Application no: H17/0983/02

Description: Extension to dwelling and double garage.

Location: Glenfield
Stockhouse Lane
Surfleet

Amendment: Reposition Garage
Dwg no. AD1

PROPOSED SITE PLAN
Scale 1:500

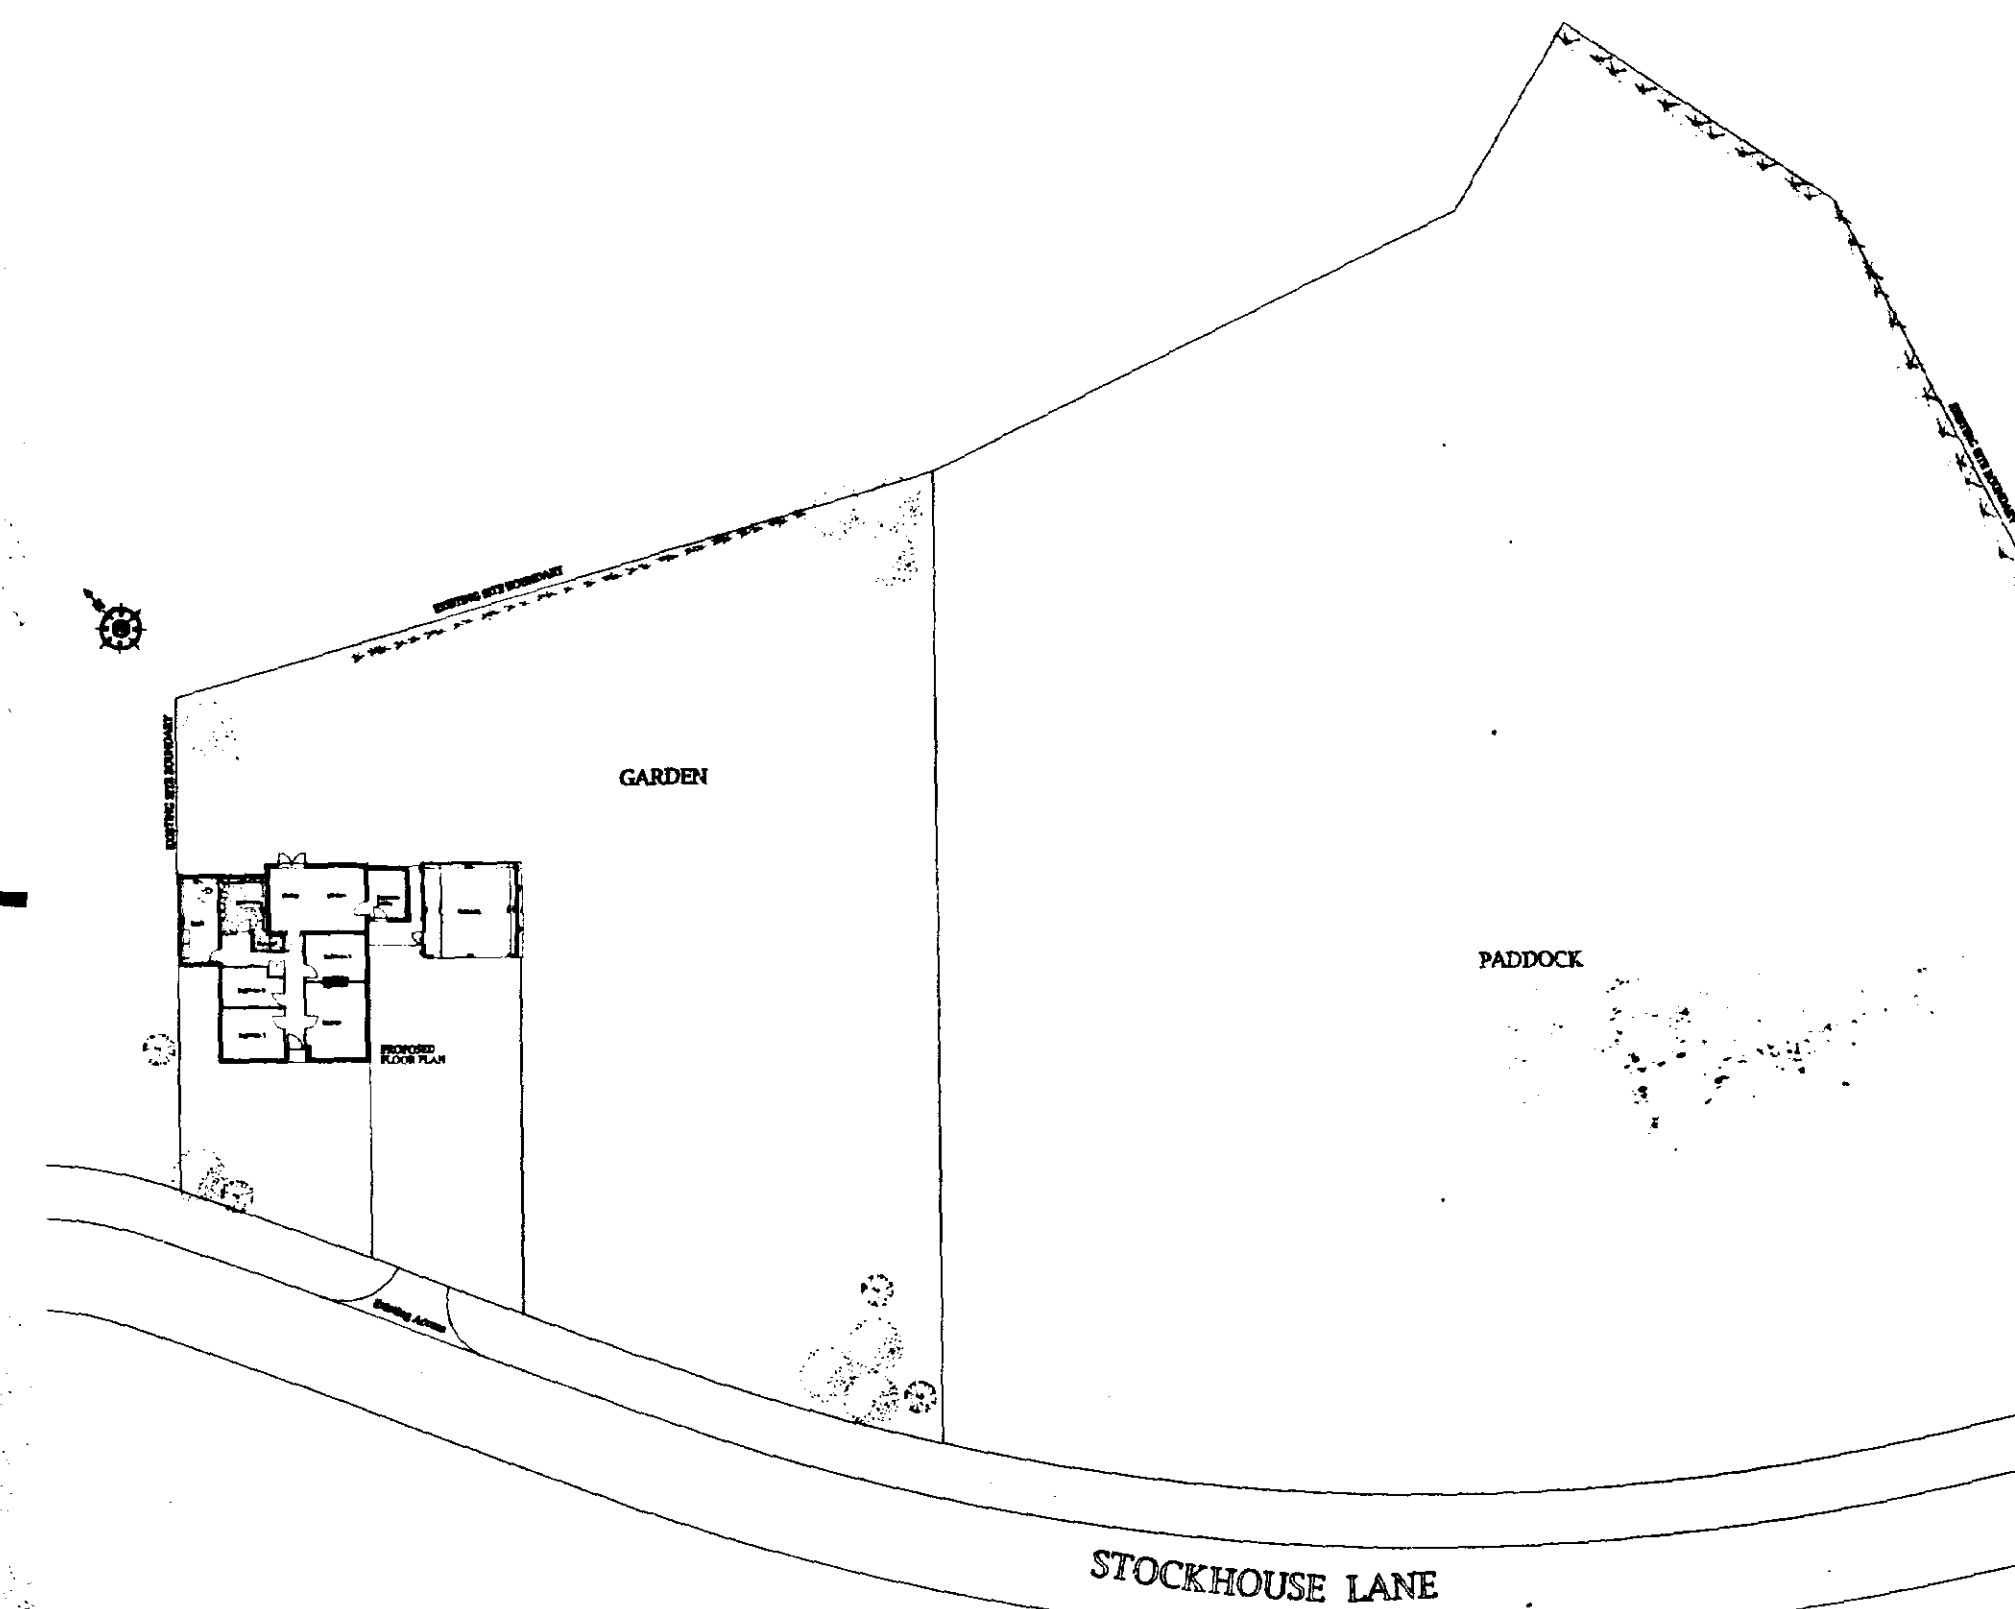
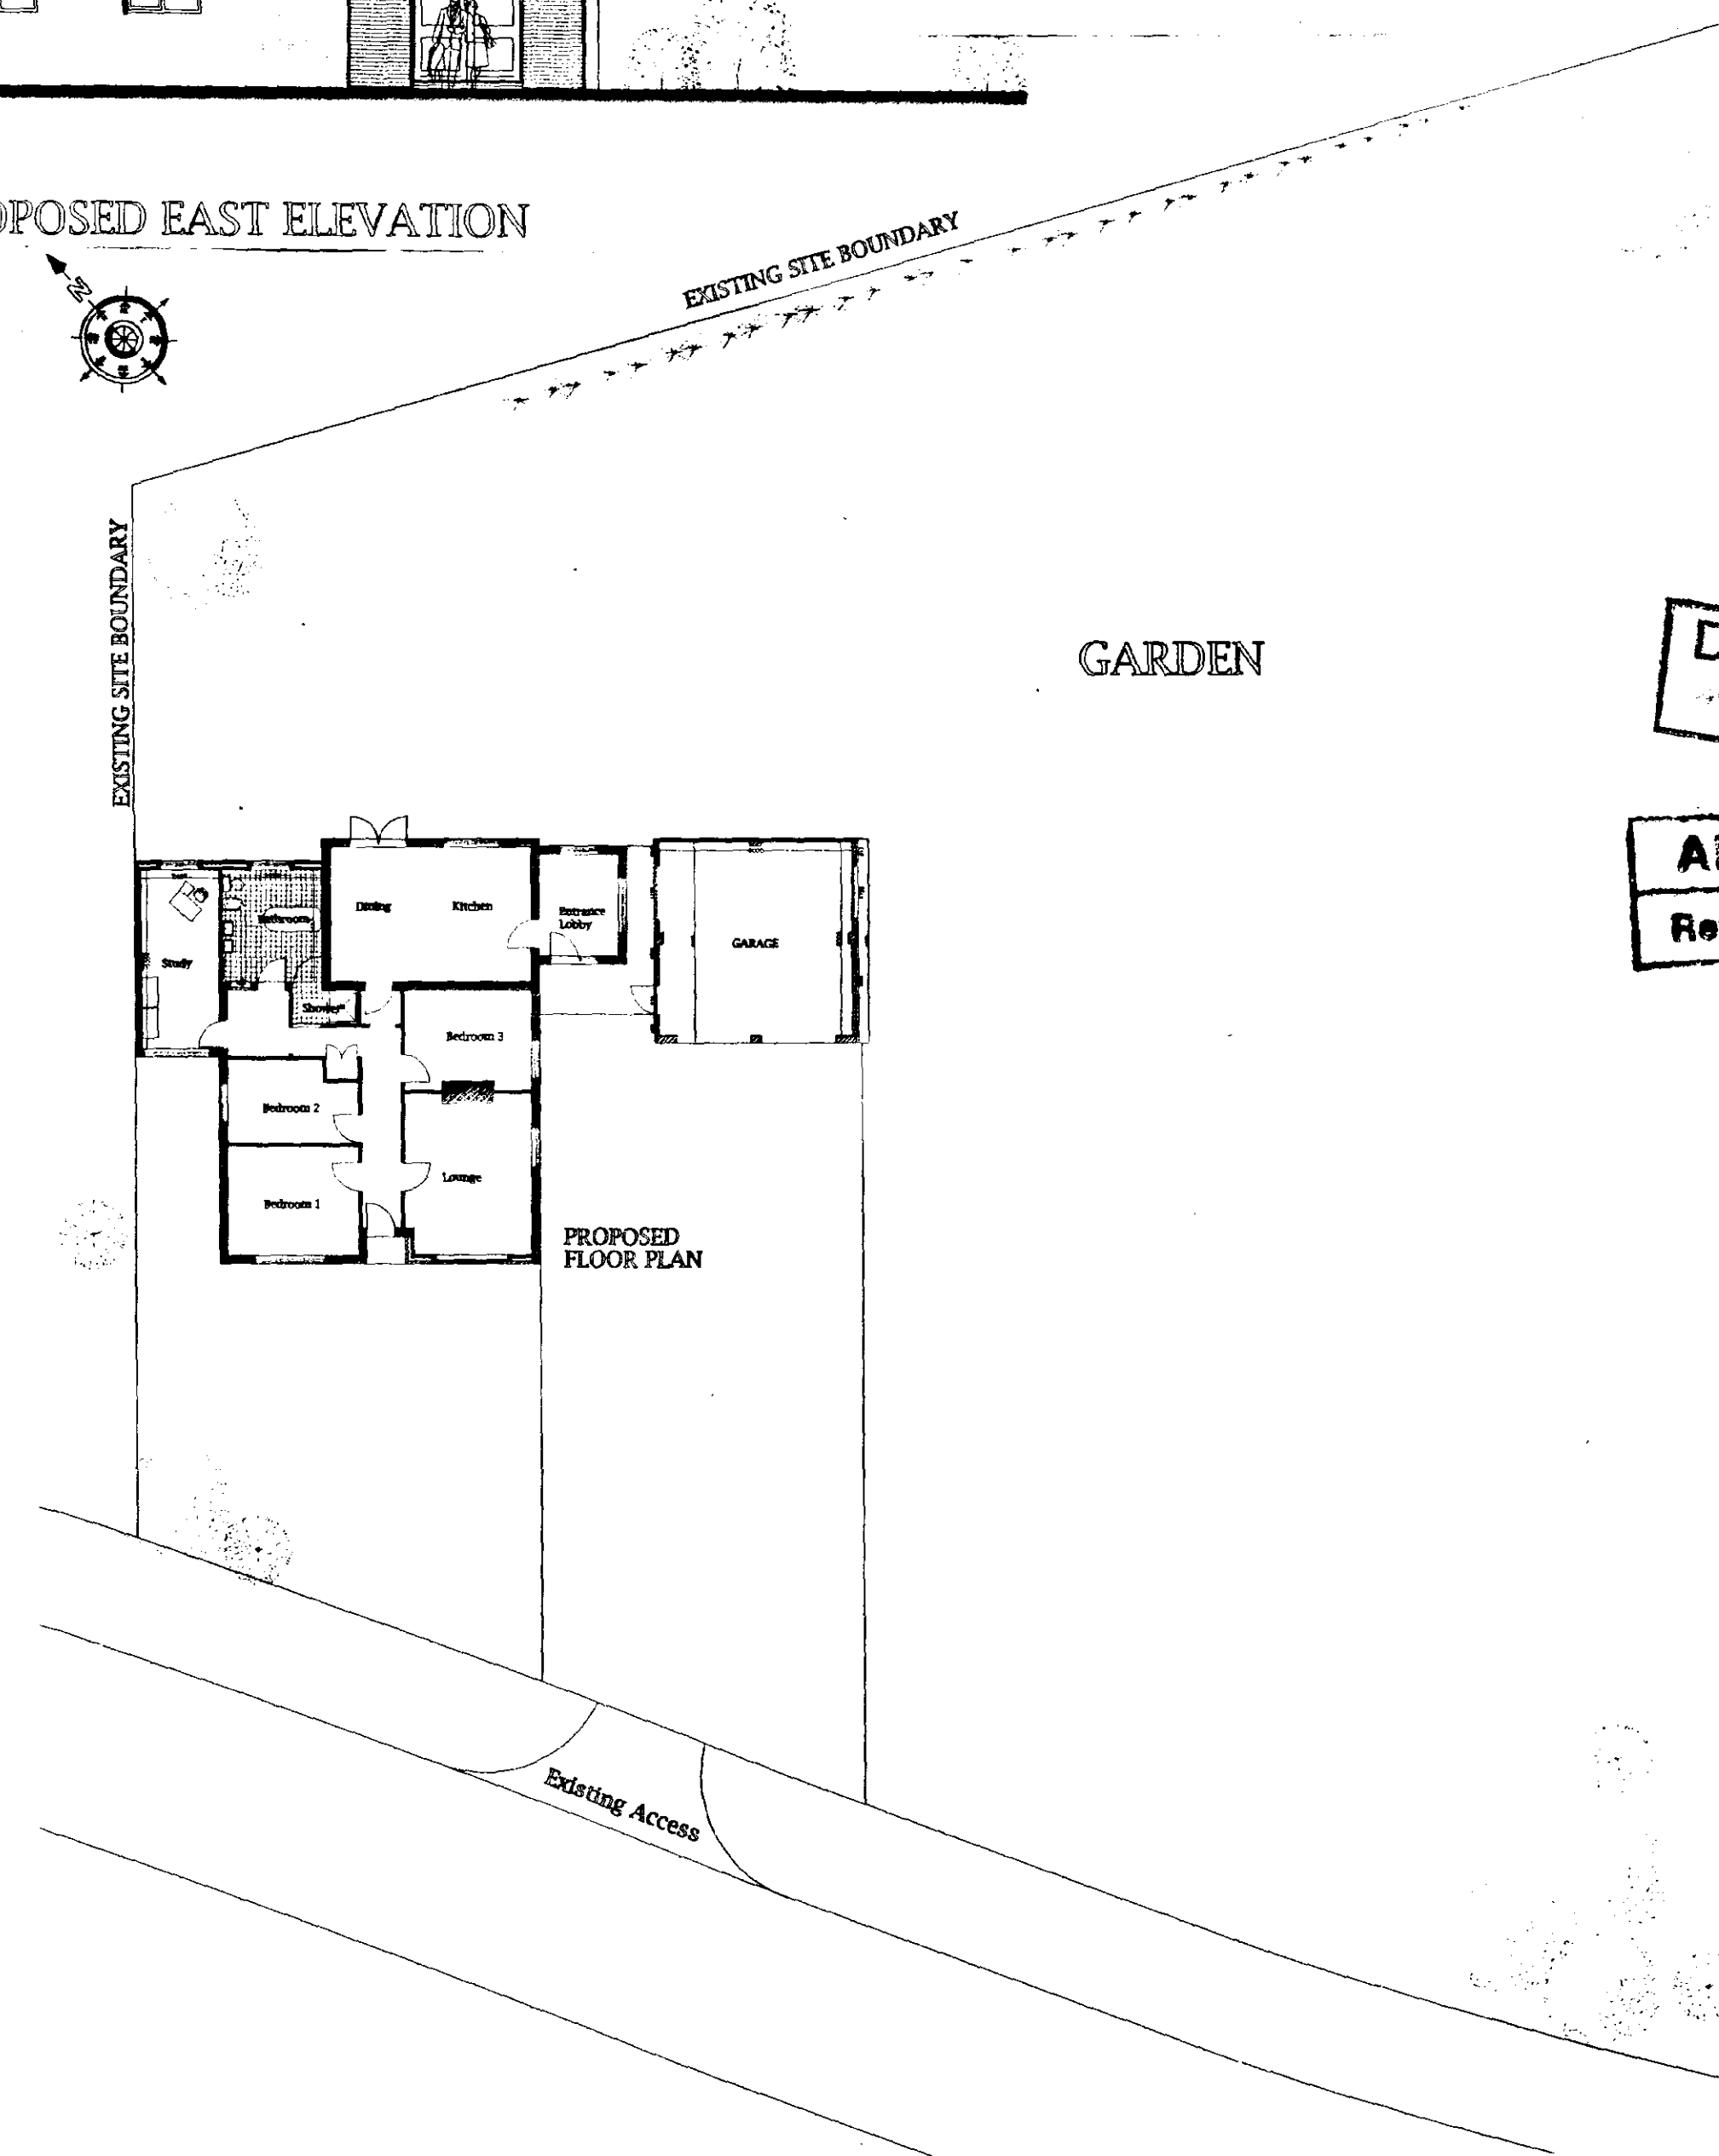
Further to your letter dated 19th November 2002, I am writing to inform you that the reason the garage was positioned as it was shown on the Application drawings, was because the garden lies totally to the north of the dwelling and in the proximity of the dwelling, receives very little sunshine due to the overshadowing of the dwelling. As you will have identified from your site visit, the play area for the children lies immediately behind the principal access and this is in shade for two thirds of the year.

Nevertheless my client, in view of your letter has instructed me to reposition the garage and four copies of the site plan are enclosed as requested.

The amended details submitted in respect of the above proposal have now been considered and there are no objections to the amendment being implemented to the extent described above.
